Application No: A/41/22/DOC
Site Address: Land North of Water Lane Angmering BN16 4EU
Description of works: Approval of details reserved by condition imposed under ref A/40/18/OUT relating to Condition No 5 - design code masterplan.

Thank you for your internet representation made on 21st March 2022 which has been recorded as an objection with the comments as follows:

Public Transport / Dappers Lane Link
(Conditions 16 and 39)

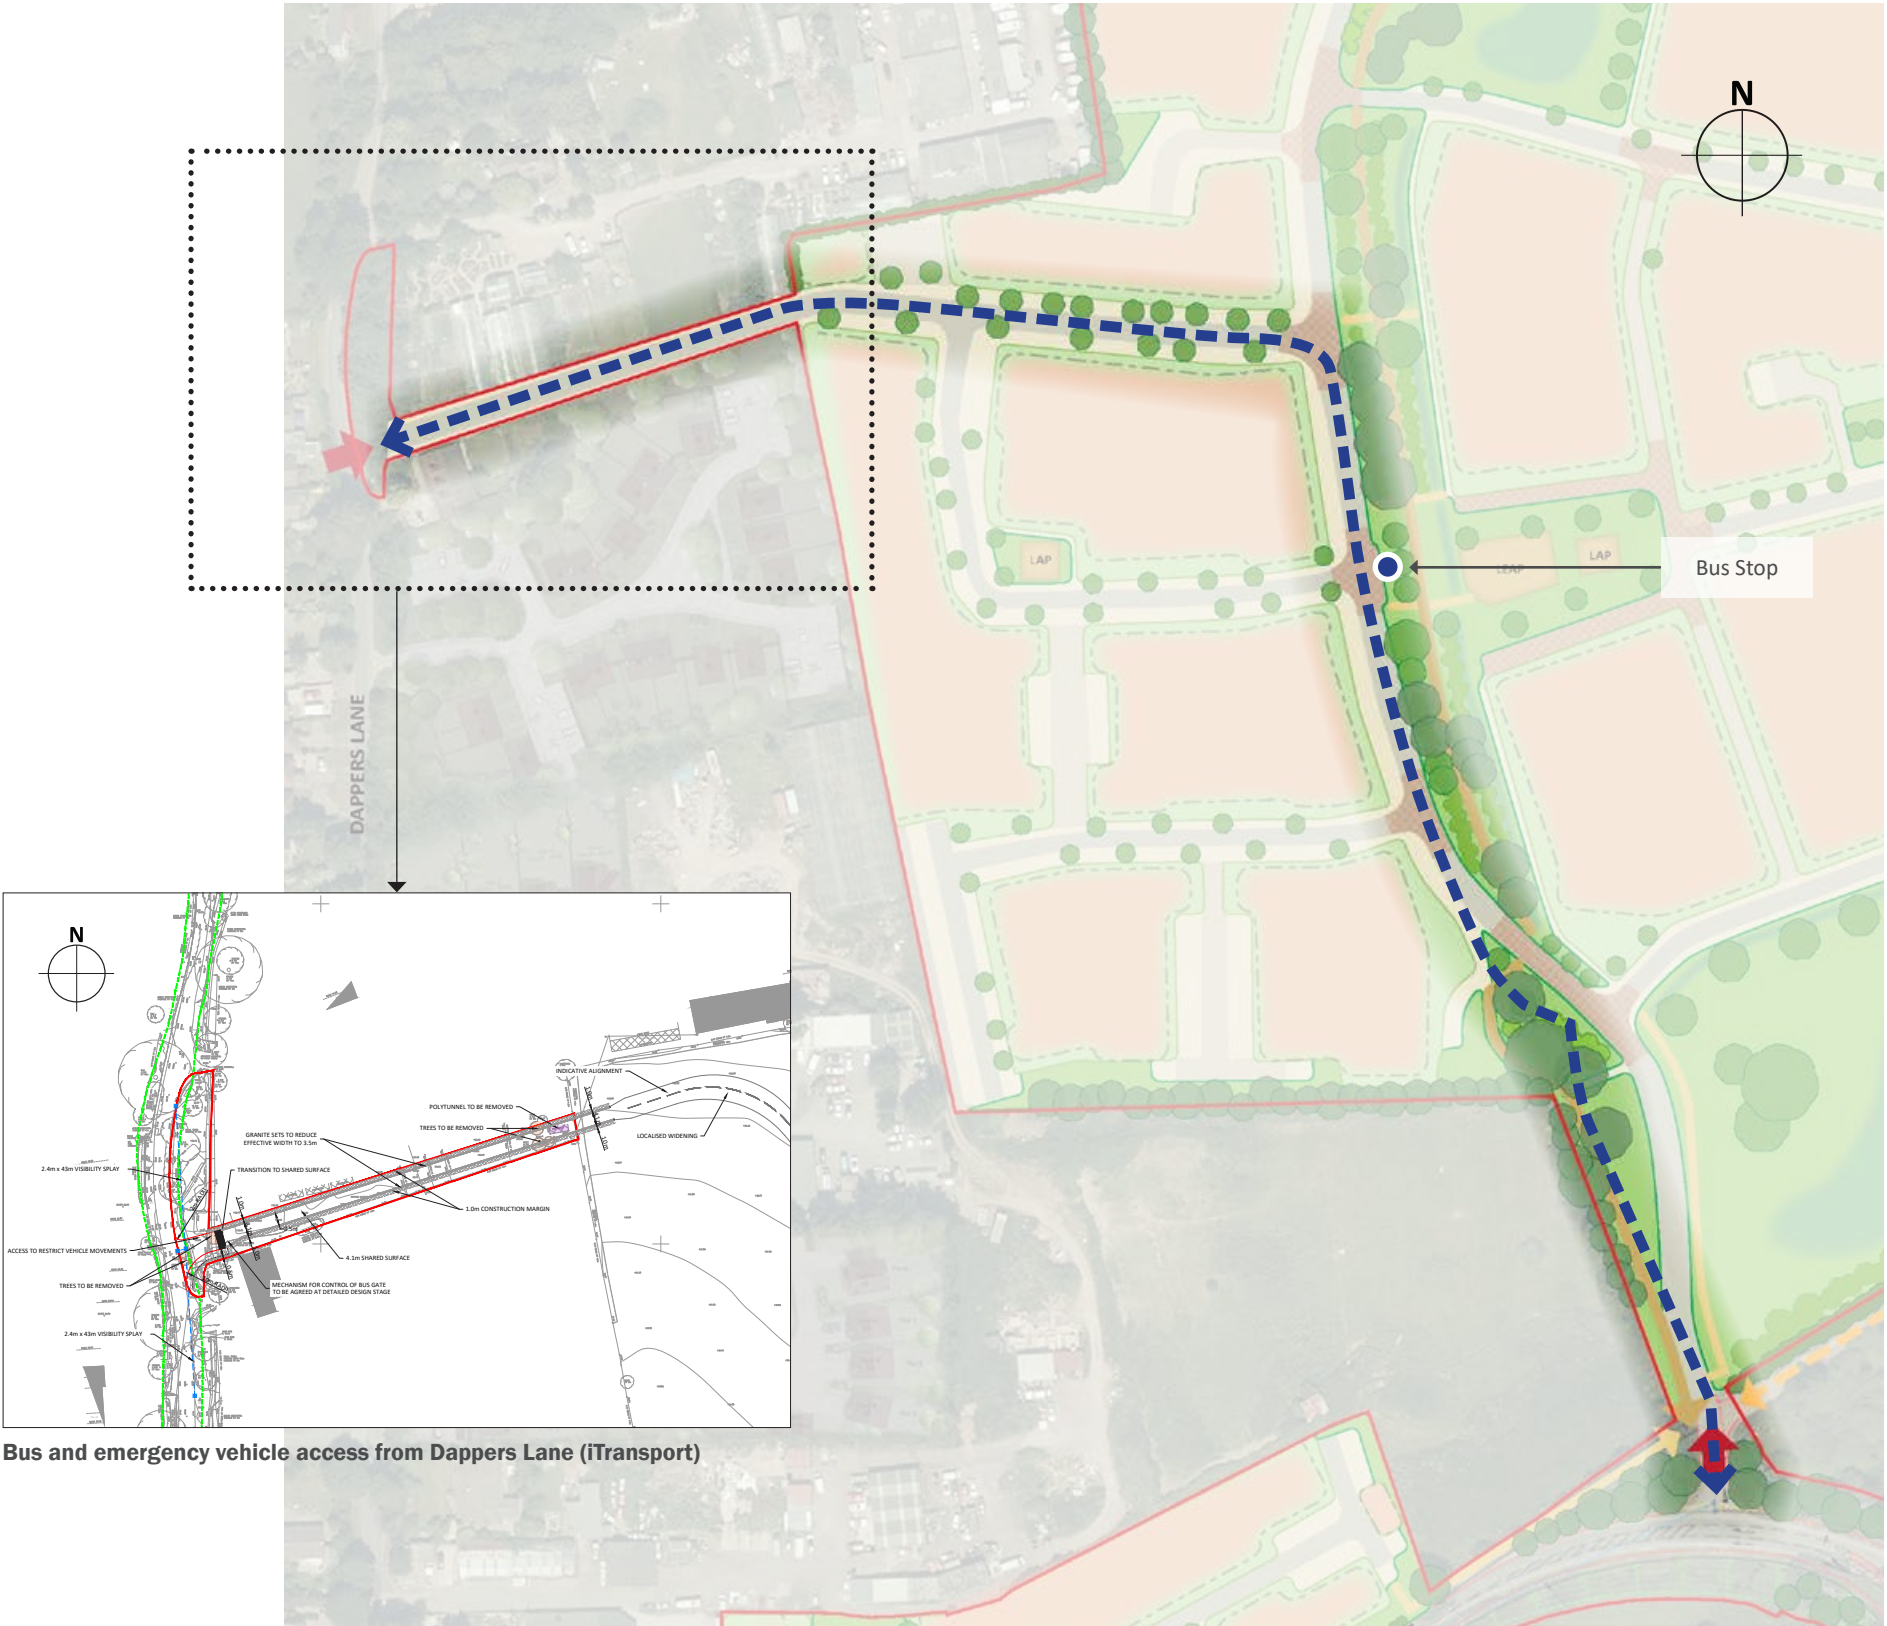
I am writing regarding this development and the previous objections raised by many people regarding the bus and emergency access between the development and Dappers lane. I see from the submitted developments that the solution to control traffic between the development and Dappers lane is still not defined and once again the developer is trying to push this issue into the detailed design phase.

As mentioned in my previous objection this is not acceptable. Even at this level of planning detail it should be confirmed and indeed mandatory that a mechanised barrier system is installed. The barrier mechanism itself can be decided at a later stage but not the principle. This should be confirmed at this level of design.

A physical barrier needs to be confirmed now and included in the approved plans.
